From: Andrew Wood
Sent: 14 May 2019 13:52
To: Planning.Responses
Subject: FW: M/27/19/NMA - Plans request & Update
Attachments: NM-248-09 Rev A Proposed Elevations.pdf; NM-248-10 Existing & Proposed Street Scene.pdf

M/27/19/NMA - Plans request & Update

PROJECT TITLE		DRAWING TITLE		No	REVISION	DATE
Proposed Development at 24 Alleyne Way, Bognor Regis		Proposed Elevations				
		STATUS	Non material amendment			
		SCALE	1:100 @ A3			
		DATE	26.03.2019			
		DRAWN BY	AP			
		DRAWING No	NM-248-09

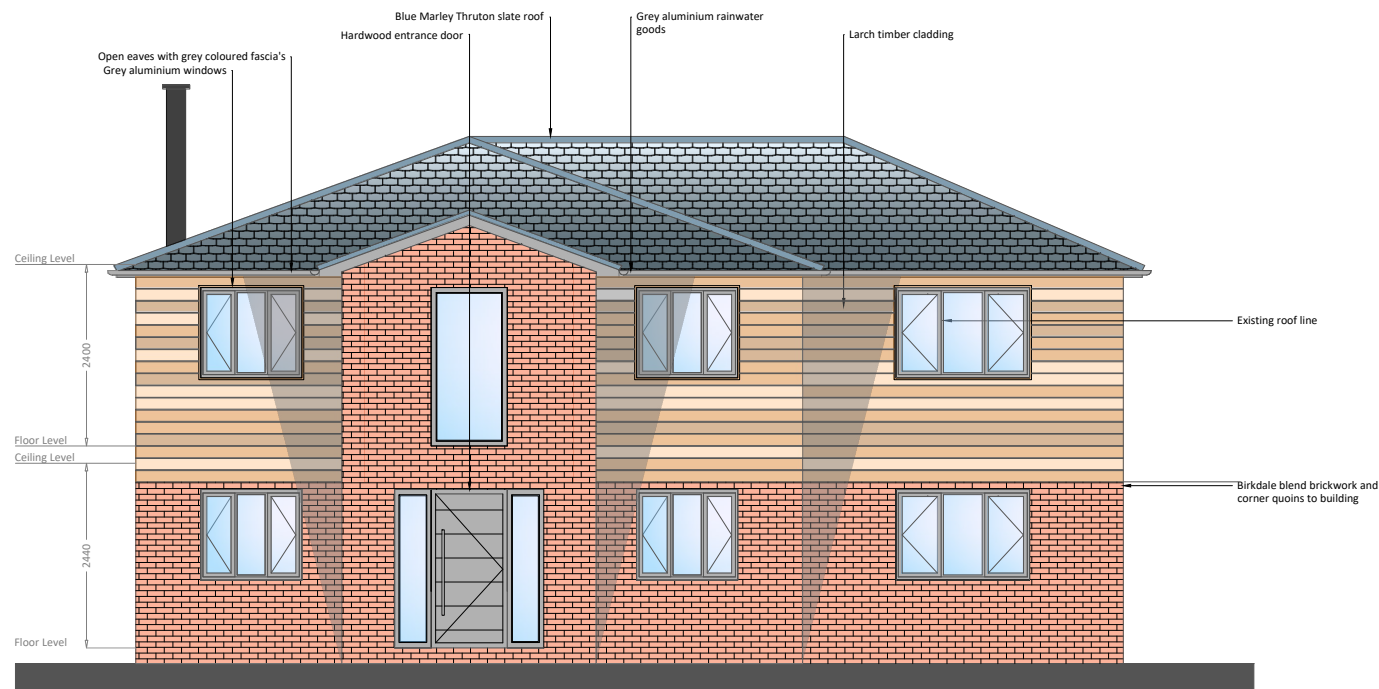
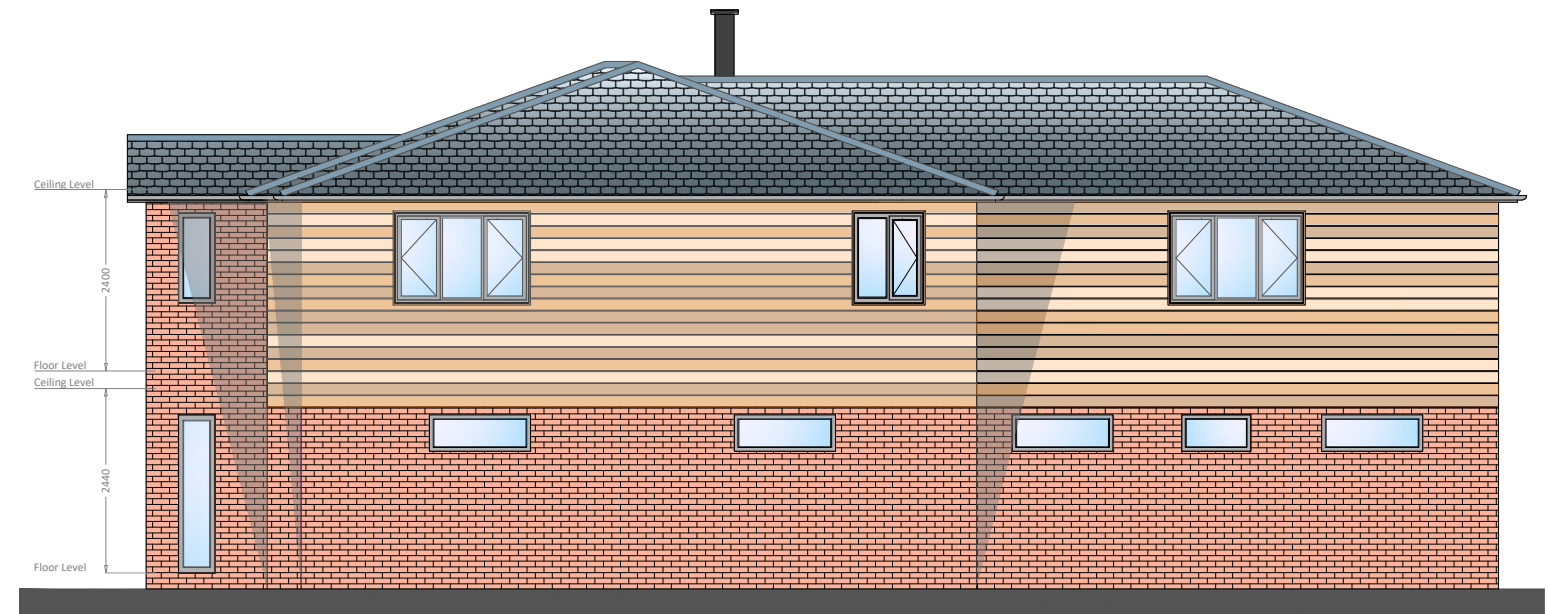
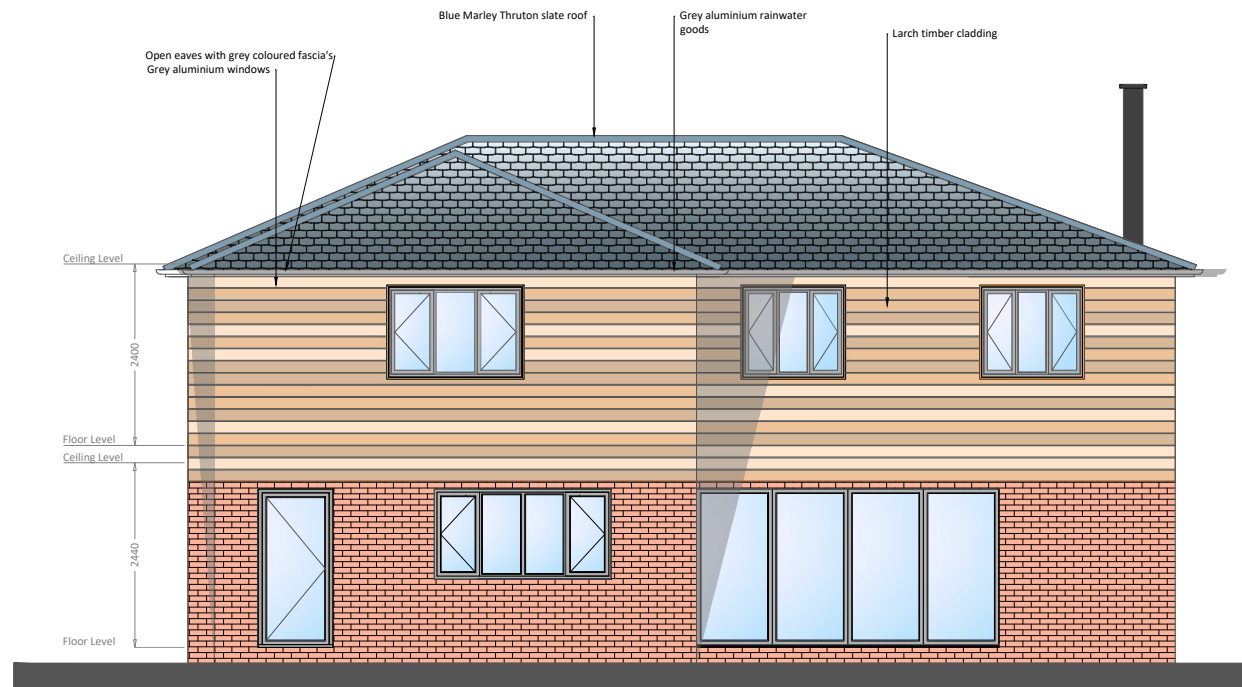
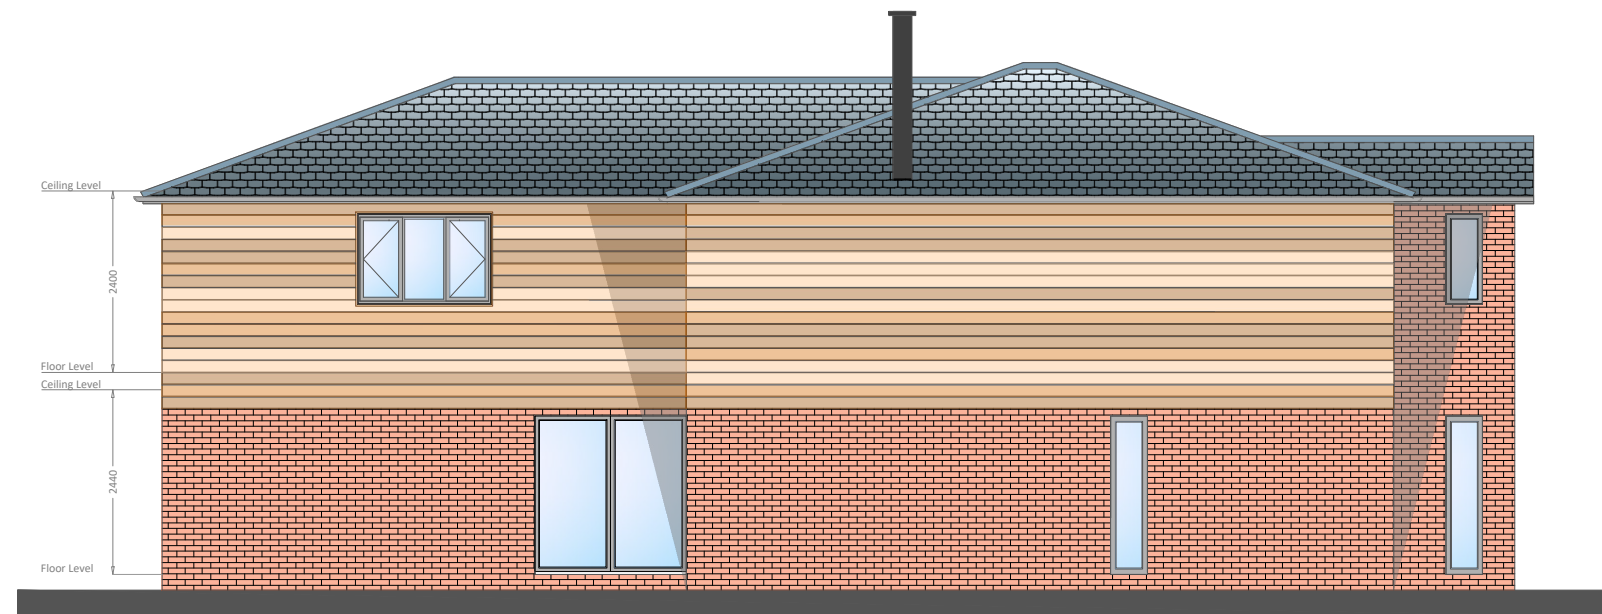
In considering the plans submitted there is no difference in height between elevations plan no. NM-248-09 submitted with M/27/19/NMA and PA-248-07 submitted with M/84/18/PL despite the description of the NMA application stating the overall height of the dwelling has increased by 30cm.

The only difference between the plans is the change of materials at first floor level. Can you please submit an accurate plan of the building which accords with what has been constructed on site and what is to be constructed in terms of the roof.

Please demonstrate on a drawing the difference between the finished floor levels of the proposed scheme under the NMA and that approved in M/84/18/PL.

I would further note that under application M/84/18/PL the finished floor levels decreased from 4.1 metres to 4.01 metres. As such a reduction in the height of the overall building would have been expected. Please explain.

The architect stated the height of the house to be 7 metres, this height was given prior to the Environment Agency setting the finished floor level. The Environment agency stipulation means the overall height of the house has risen at ground to finished floor level. The dimensions of the rest of the house remain the same.

PROJECT TITLE Proposed Development at 24 Alleyne Way Bognor Regis	DRAWING TITLE Existing & Proposed Street Scene		No	REVISION	DATE
	STATUS Non material amendment				
	SCALE 1:150	DATE 09.05.2019			
	DRAWN BY	DRAWING No NMA-248-10

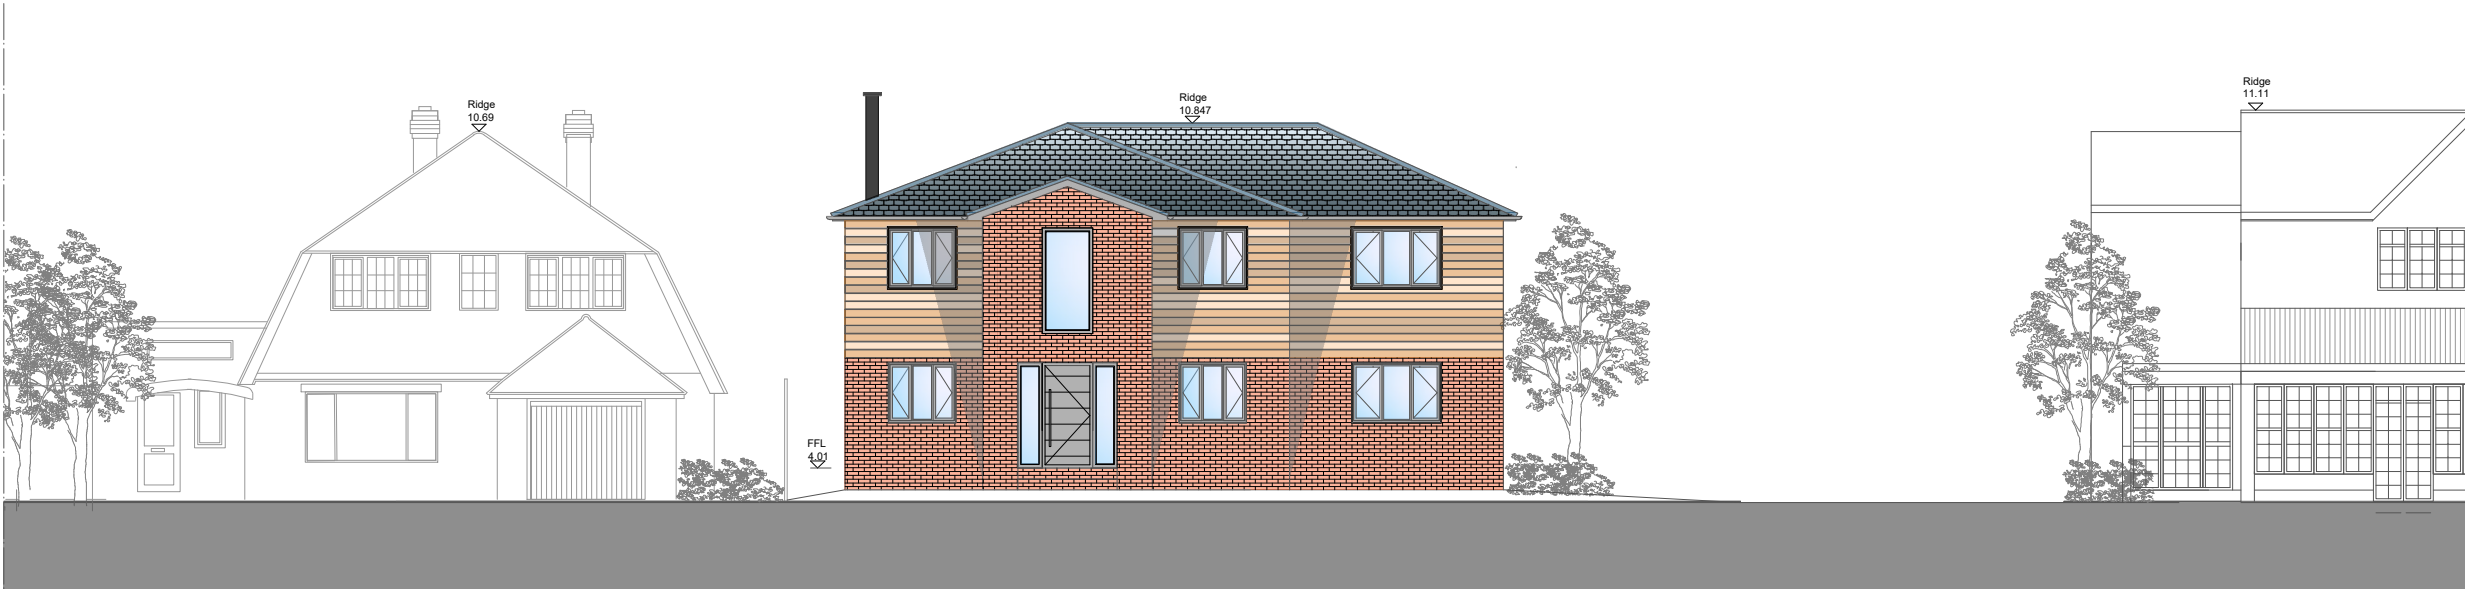
Can you also submit an accurate strip elevation including 22 and 28 Alleyne Way.

The construction as it has been progressing has attracted a number of significant complaints alleging it is not being constructed in accordance with approved plans. What is clear is the windows at first floor height are significantly higher than shown on the strip elevation which, while it is acknowledged that the primary plan to scale is the elevation plan, is a matter of significant concern.

The street scene now shows that the new dwelling sits within its surroundings. The ridge of the dwelling will be the highest point which is set a good distance away from the neighbouring ridge. The majority of the remaining roof will be 7 metres or under.
